Dean Moor Solar Farm

Cultural Heritage Technical Note

August 2025
Prepared by: Stantec
PINS Ref: EN010155
Document Ref: D2.33
Revision: 1

Environmental Statement: Chapter 7 – Figure 7.6 1-5 Landscape Strategy Plan on behalf of **FVS Dean Moor Limited**

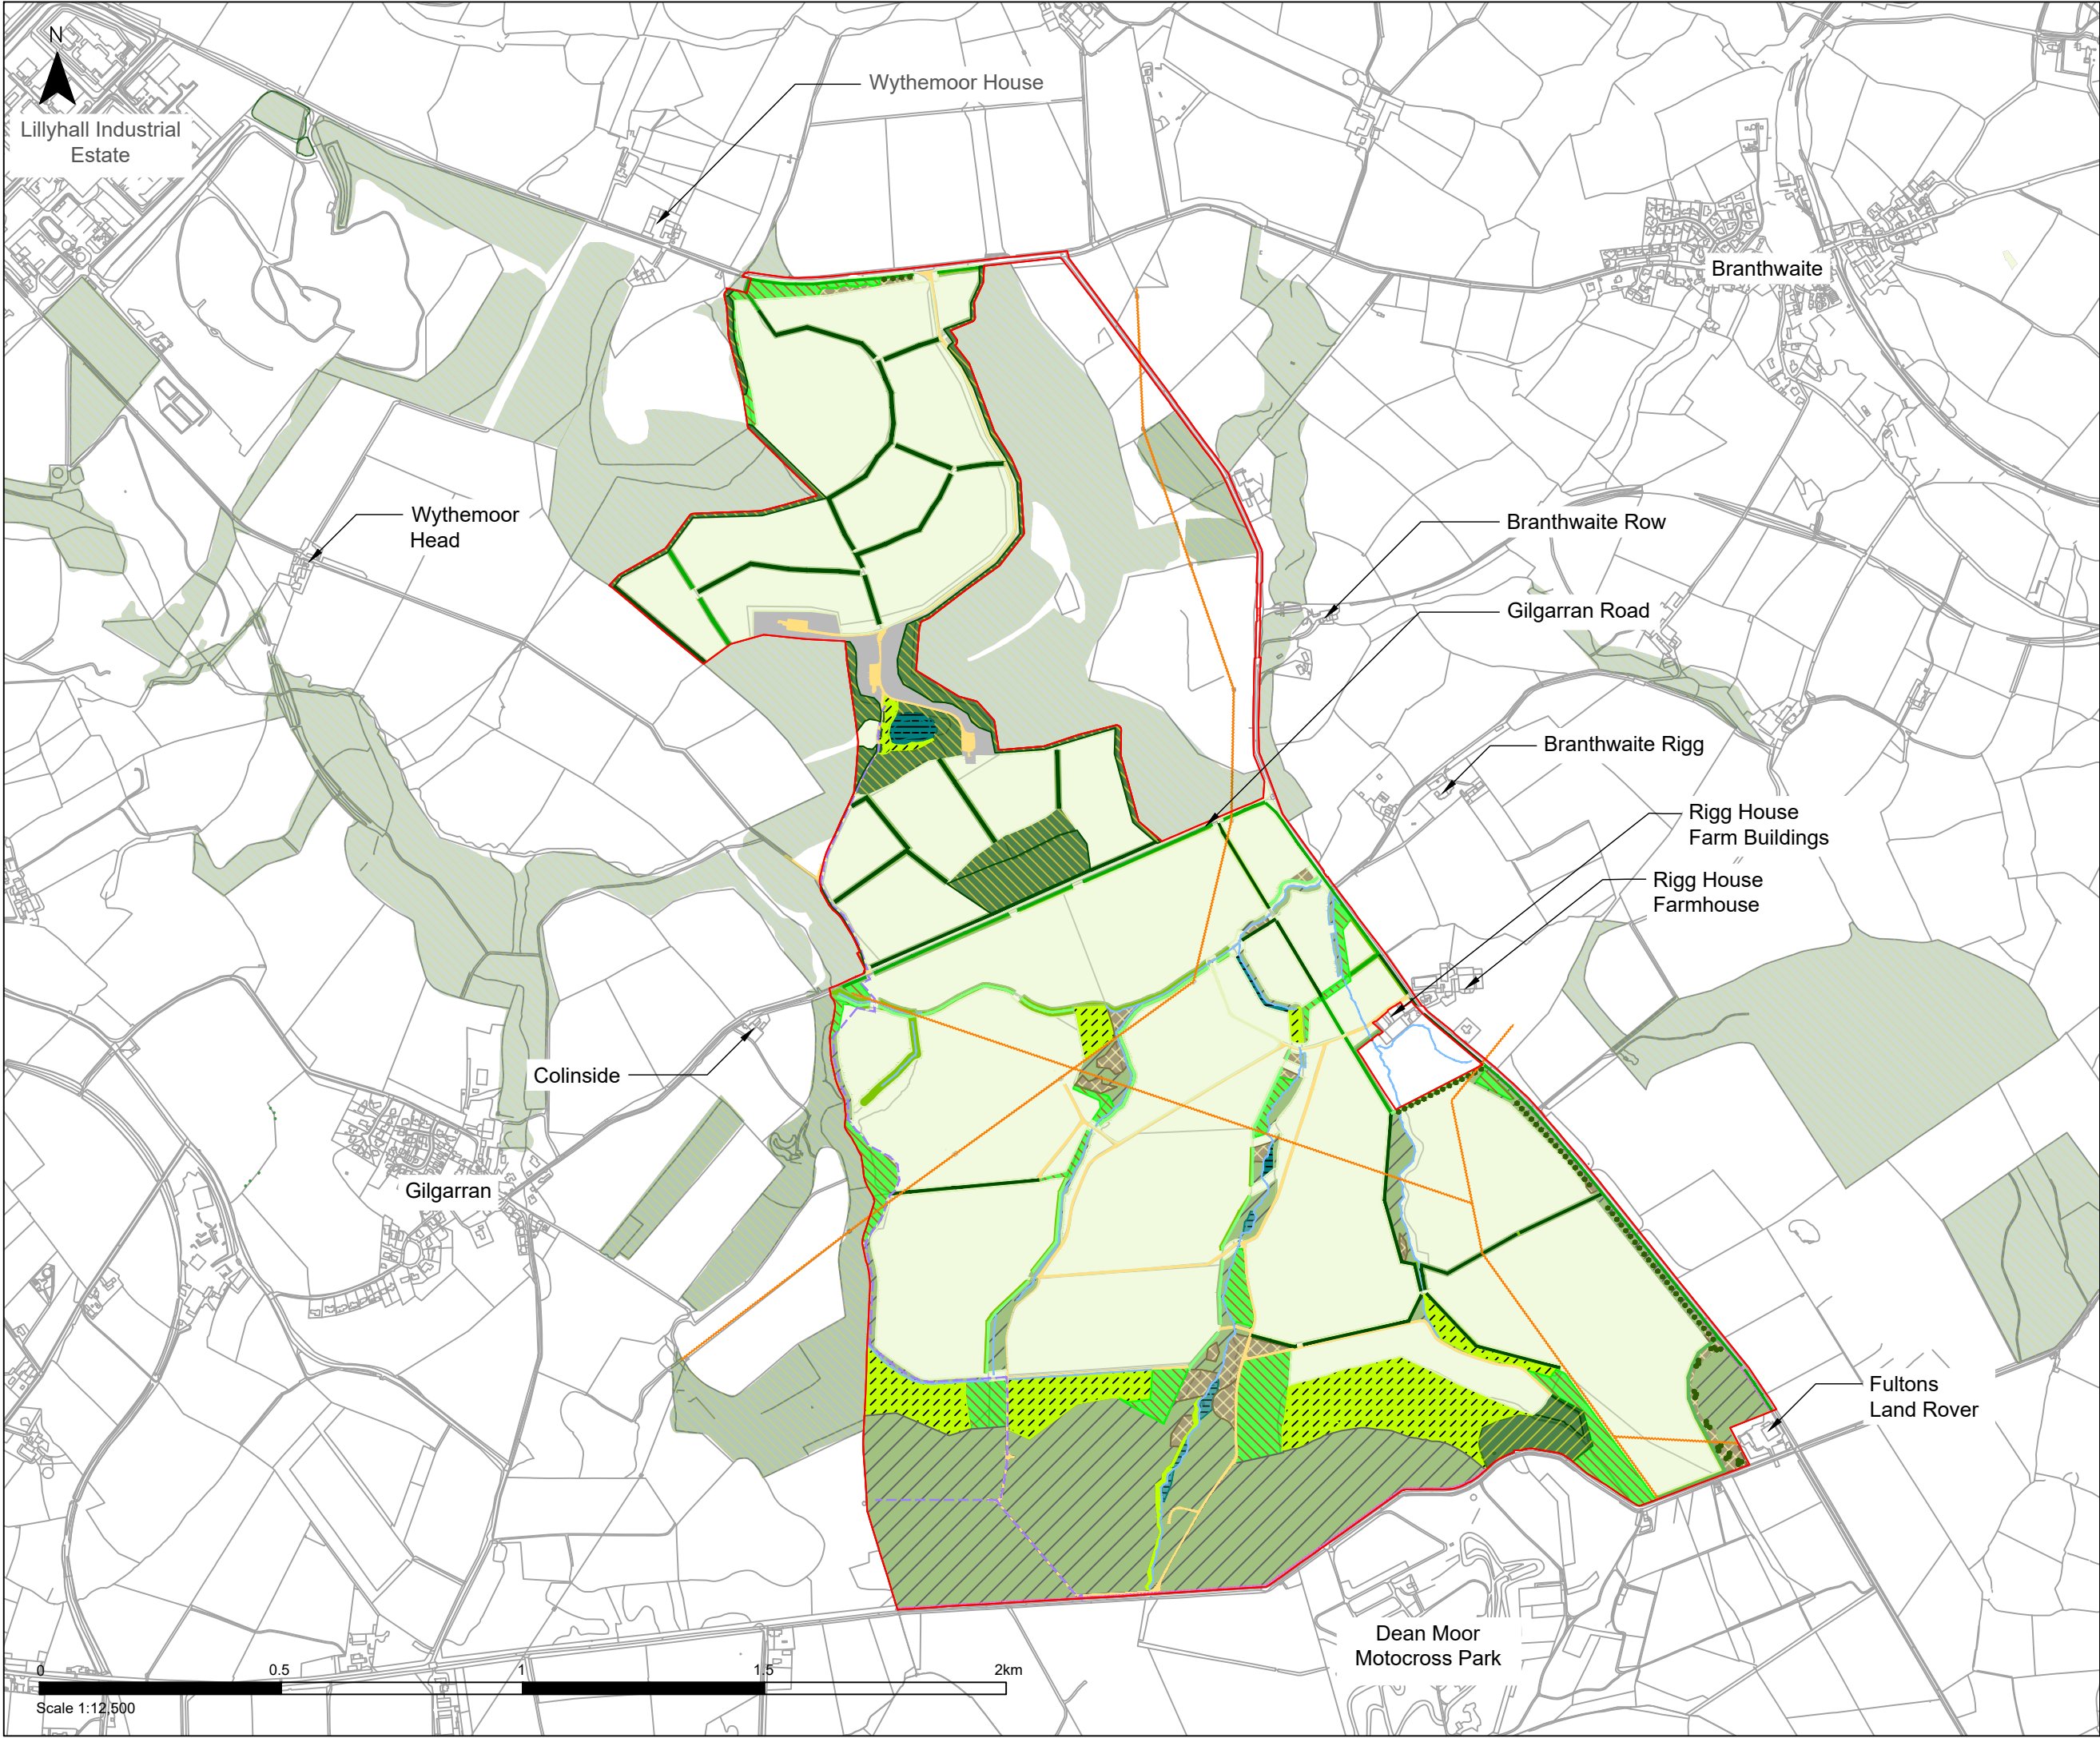
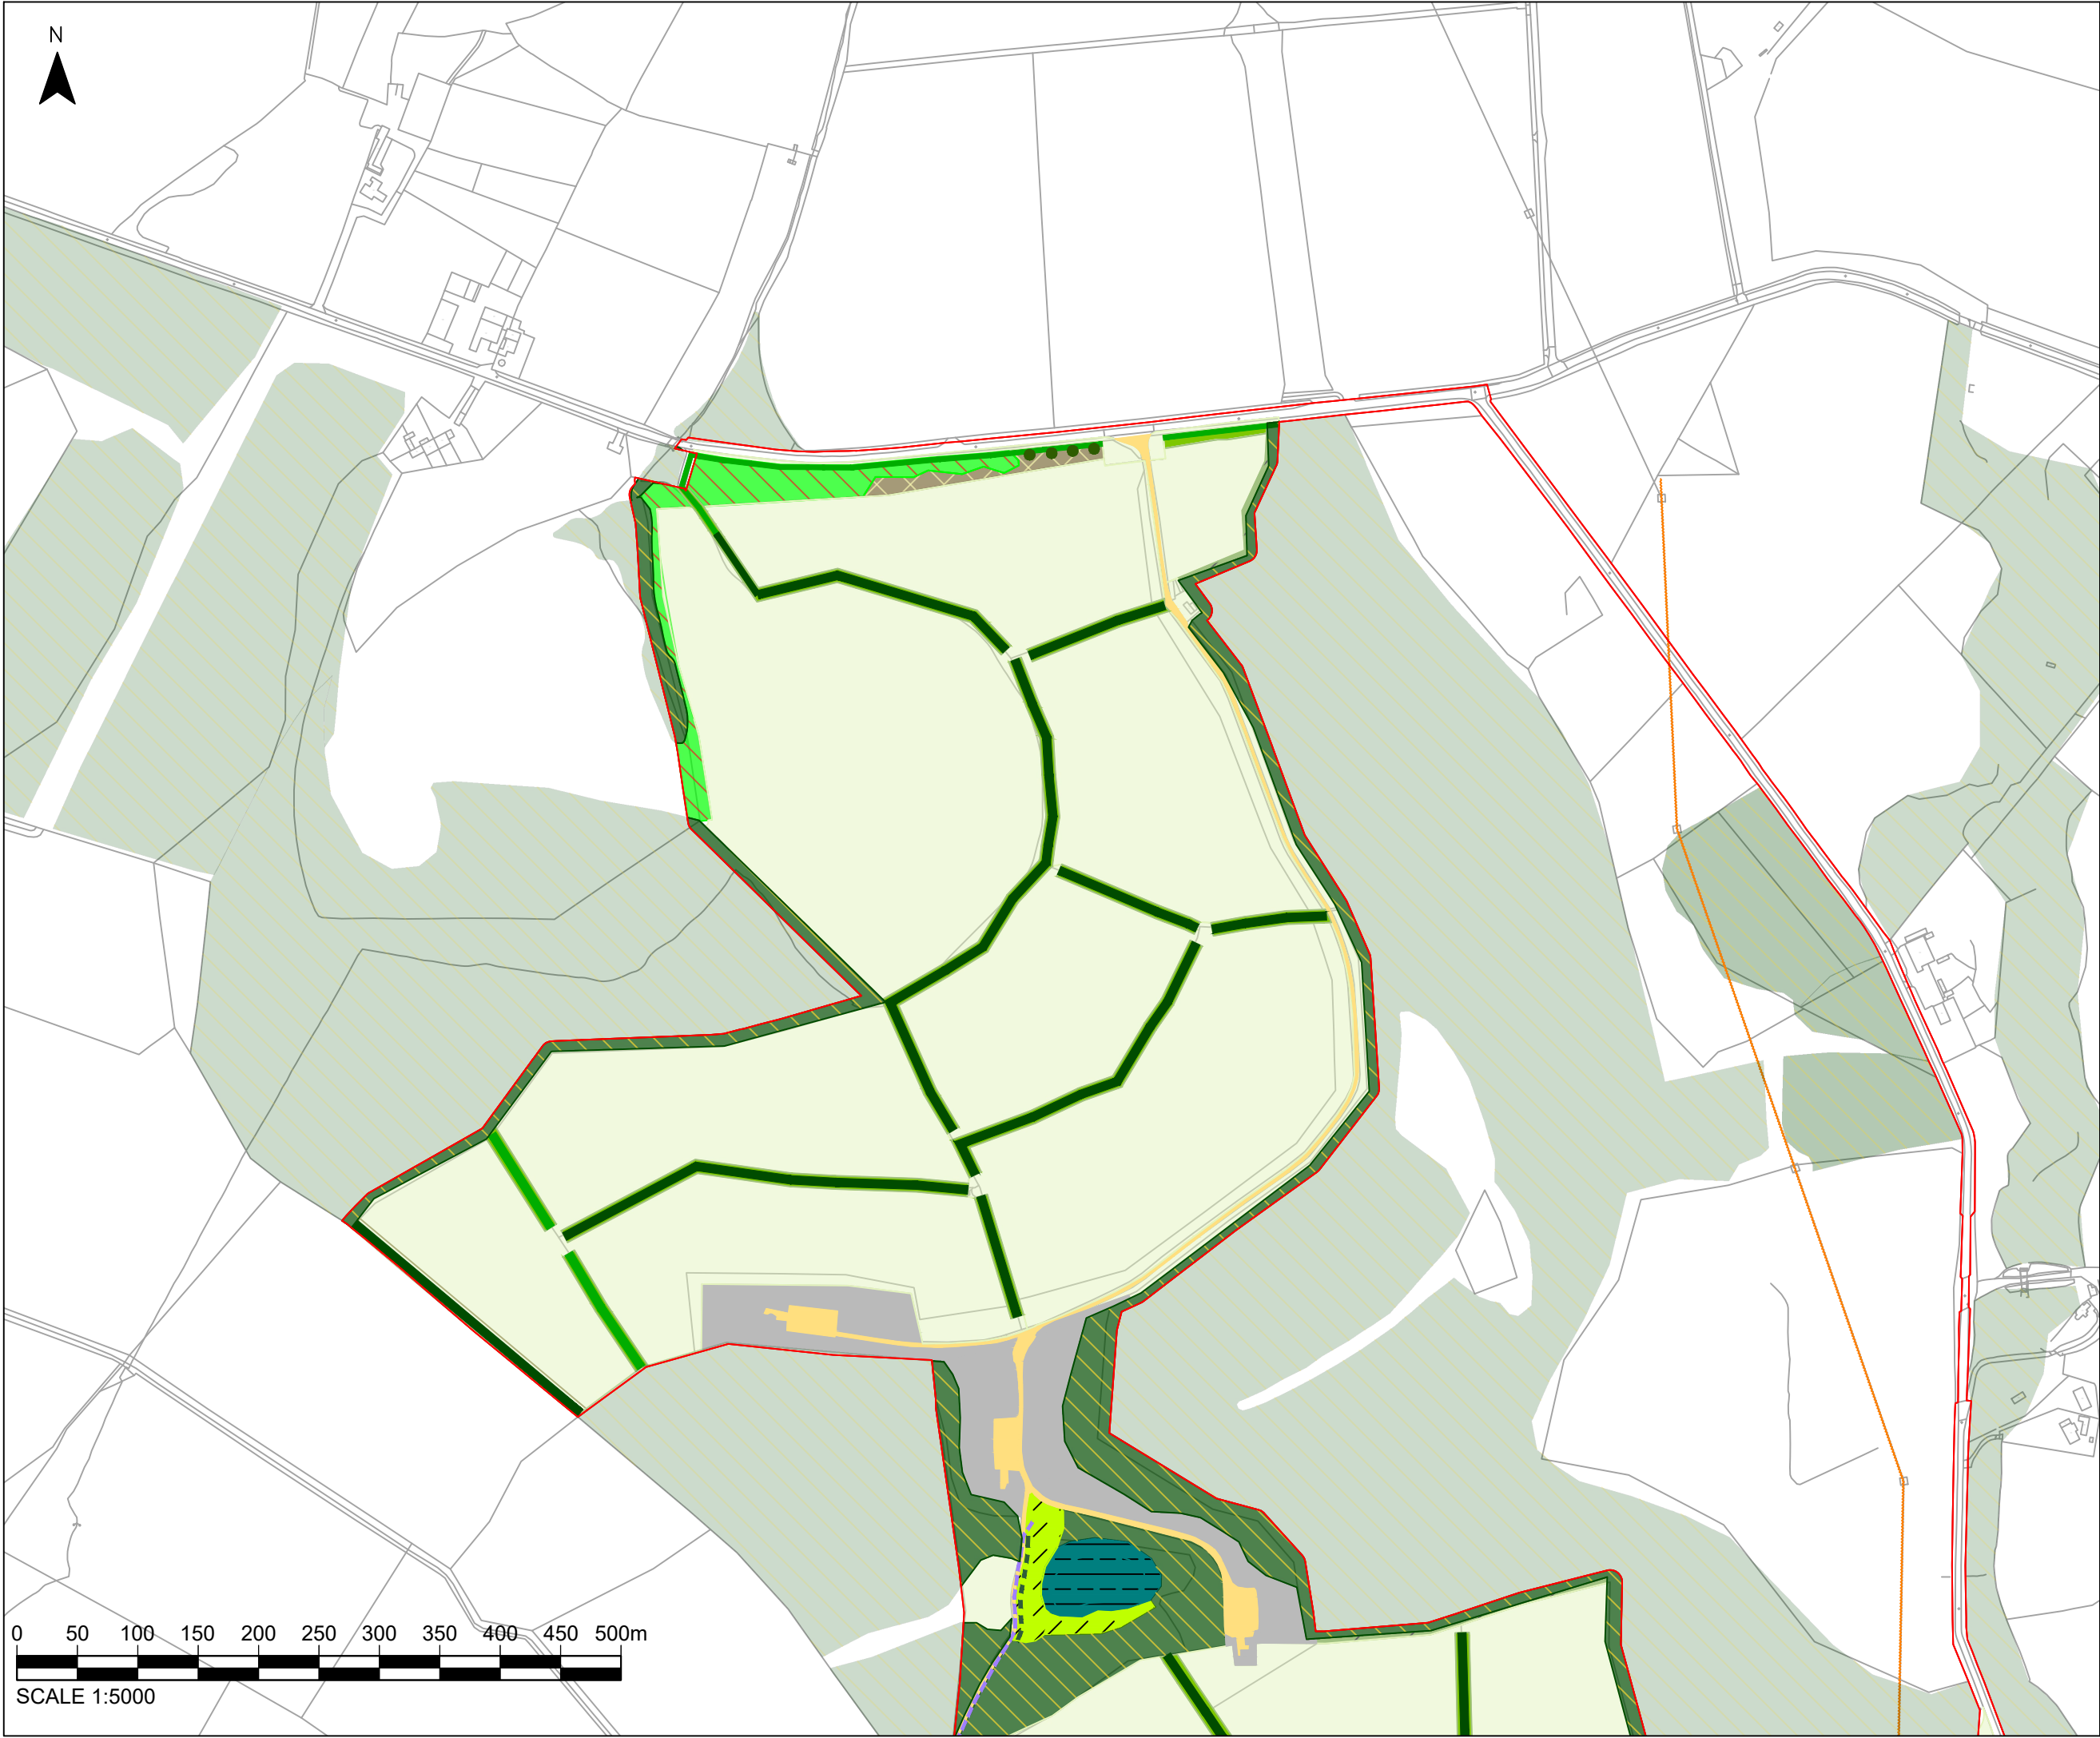
- 1.1.3 *‘Table 2.1 Grade II listed buildings and Grade II Registered Parks and Gardens should be placed in the ‘High’ category and not the ‘Medium’ category. Para 2.2.8 makes reference to the use of Design Manual for Roads and Bridges LA 106 as it ‘provides a useful framework for cultural heritage assessment’. As such, the criteria contained within Design Manual for Roads and Bridges LA104 would have been more appropriate – which assigns a ‘High’ value to receptors of ‘national scale’. Grade II listed buildings are designated to their architectural or historic interest on a national scale (as are Grade II Registered Parks and Gardens).’*

- 2.2.3 The receptor is situated approximately 150m from the Site boundary. The farmhouse has extensive views across the adjoining landscape, due to the surrounding topography; with the farmhouse situated on a slope which falls away towards Dean Moor. The views from the rear of the property looking across the Site will be affected by the Proposed Development. Whilst the panels comprise low level infrastructure, they will foreshorten long-distance views, resulting in a change to the characteristics of the receptor setting and eroding the rural open nature of the landscape

- 2.2.4 The landscape mitigation proposes a green infrastructure buffer, which has been included within the Works Plans [APP-007] and is reinforced by proposals in the Landscape Strategy Plan (LSP) (ES Figure 7.6.1 – 7.6.5) [APP-088]. This buffer surrounds the part of the Site in closest proximity to the receptors with proposals to include new landscape structural elements (trees/scrub) to help screen the most direct near-distance views.

- 2.2.5 The LSP also includes reinforcement of existing hedgerow field boundaries across Areas A and B, which are expected to also help break up views and prevent a ‘block’ appearance. As per the Design Parameters Document (DPD) [APP-049] the Solar PV infrastructure (Work No. 1) will have vegetated ‘aisles’ between rows of solar panels which to avoid the appearance of a continuous façade, especially when viewed from a partial or full side elevation of the arrays which will be oriented with panel facades facing south, as is the case from this receptor to the west/north-west.

- 2.2.6 These measures ensure that the visual impact from the closest panels (located at approximately 150m from the receptor) is reduced. In summary, it is considered the proposed landscape mitigation would minimise the impacts caused by the Proposed Development.
